AW-344-14-HH – Objection to roof change – 20-4-2014

OBJECTION to removal of clay tile roof AW/344/14/HH – 68 The Drive – within
Craigweil House Conservation Area and Craigweil House Area of Special Character

ROOF PLAN

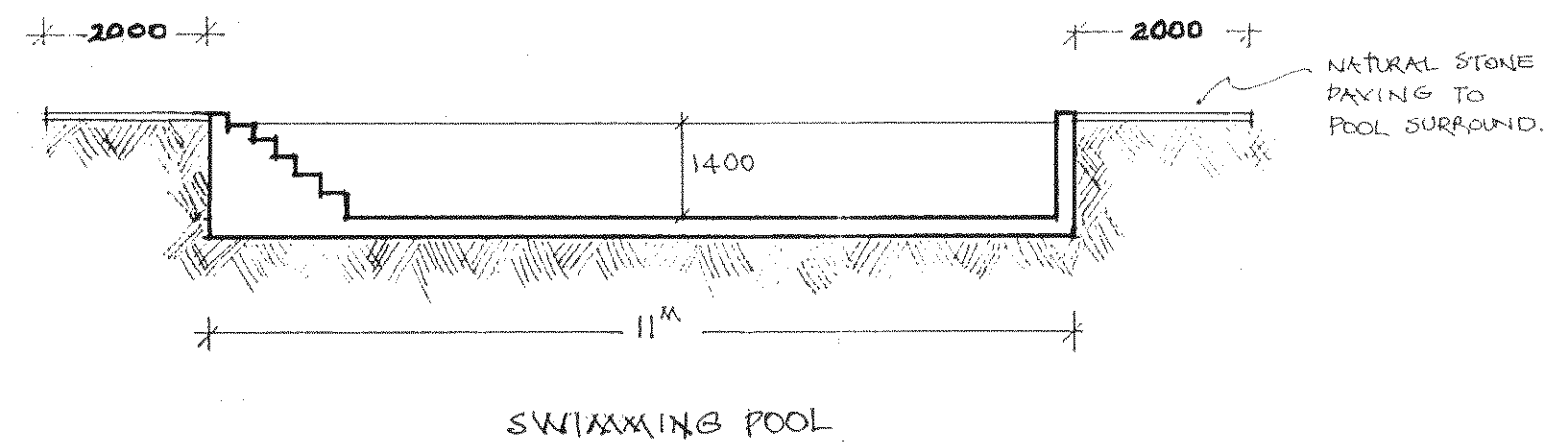
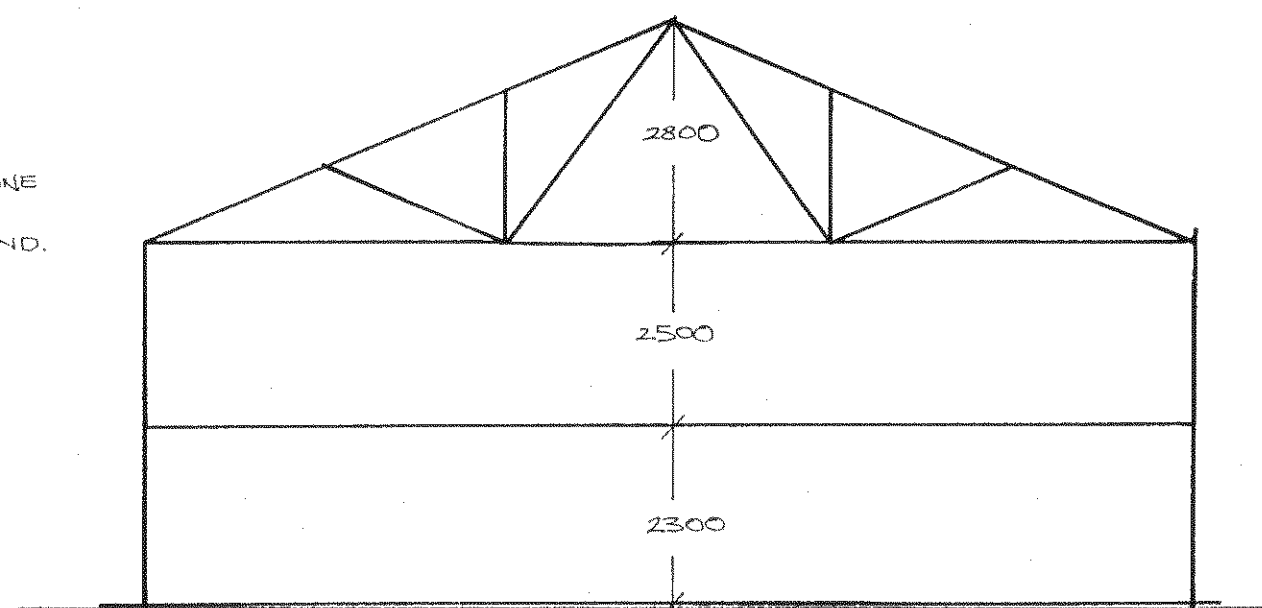
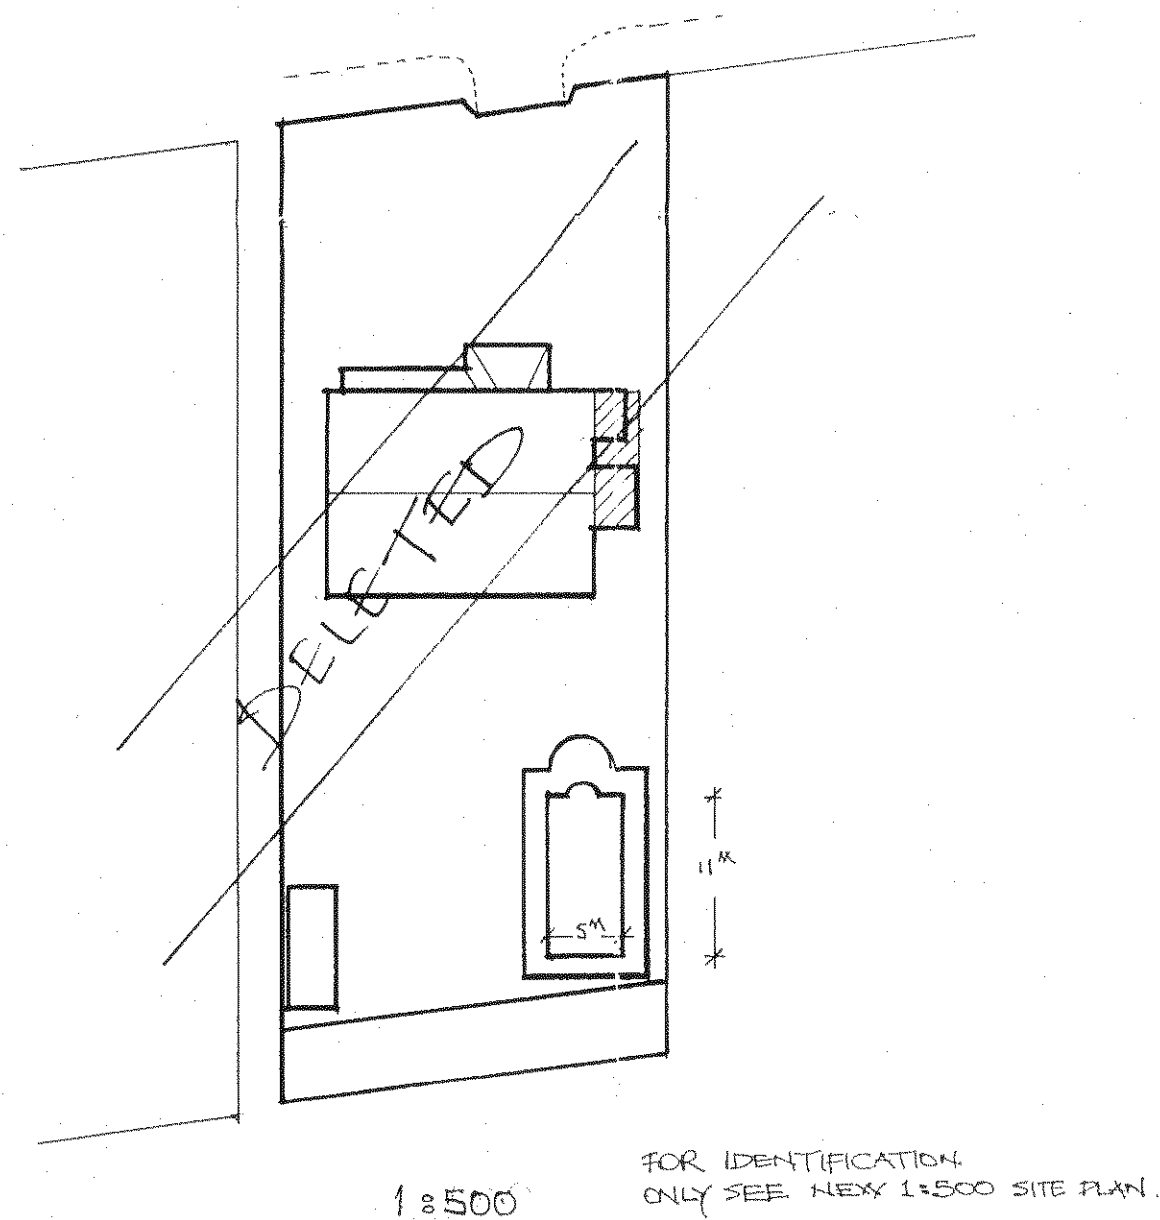
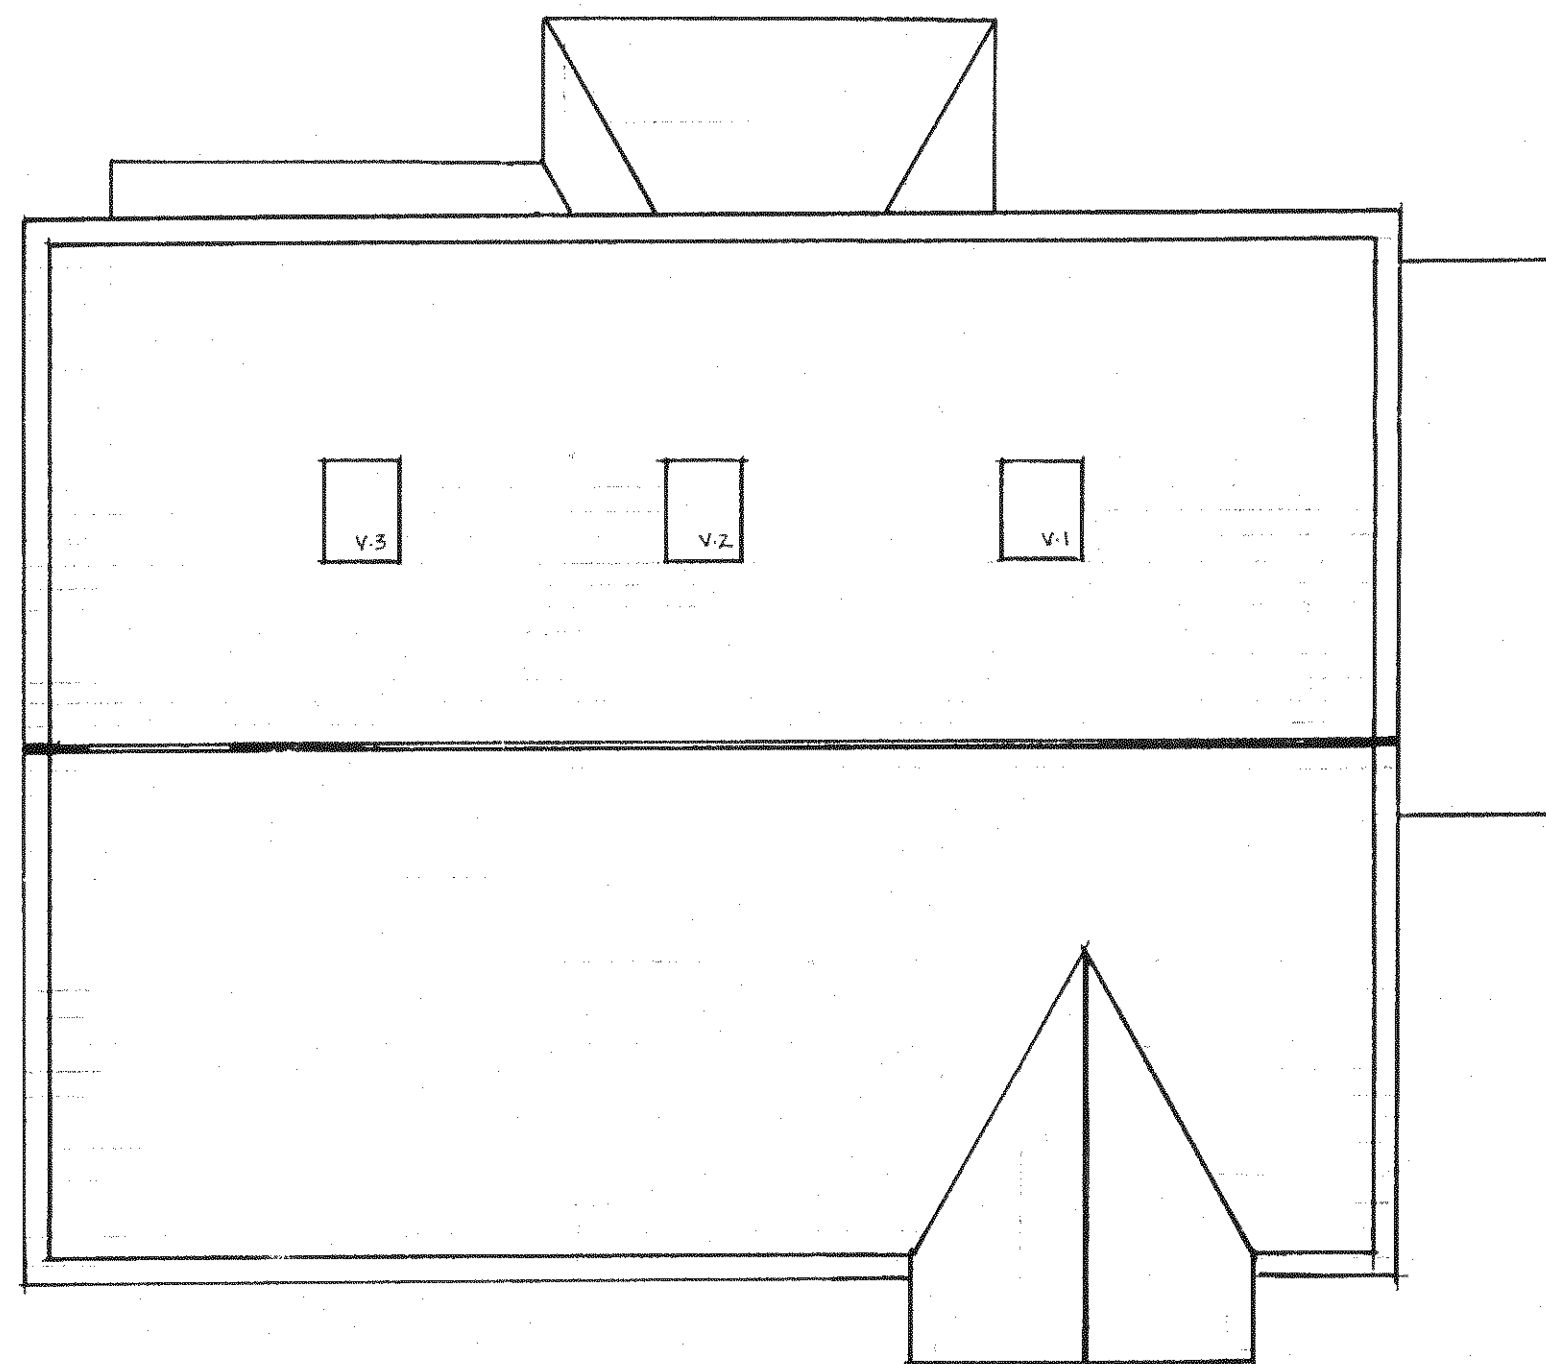
We have made clear our objection to the removal of the existing traditional Sussex clay tile roof and its replacement with Welsh slate and we feel, from reading the Officer's report to the Development Control Committee Councillors, that this issue has received scant attention – far less than its importance warrants. The stark and harmful effect the change of colour will have upon the Conservation Area generally and the Heritage Asset (Locally Listed) house at No. 66, in particular, has been accorded far less weight than its adverse effect on the immediate area demands.

These additional controls allow the Local Planning Authority (LPA) to control works which may have a negative impact on the *character and appearance of the area* – and CHECAA maintains that such will be the impact if a black roof is to be allowed where the original design concept of Auty/ Du Cros in the early 1930's which was to see local Sussex building materials of high quality used. These extra controls would serve to preserve (cause no harm) or enhance the established character of the conservation area.

A black roof is not in keeping with the character and appearance of Craigweil and flies in the face of ADC's latest, and most detailed, Conservation Area Statement created after massive research and containing great input from English Heritage and the previous Conservation Officer of vast experience.

‘...a distinguishing characteristic on many beach frontages is the traditional Tamarisk hedging. Herringbone and tile creasing are important features of the Auty designs and the traditional construction materials are of local (Sussex) stock bricks and PLAIN CLAY TILED ROOFS’.
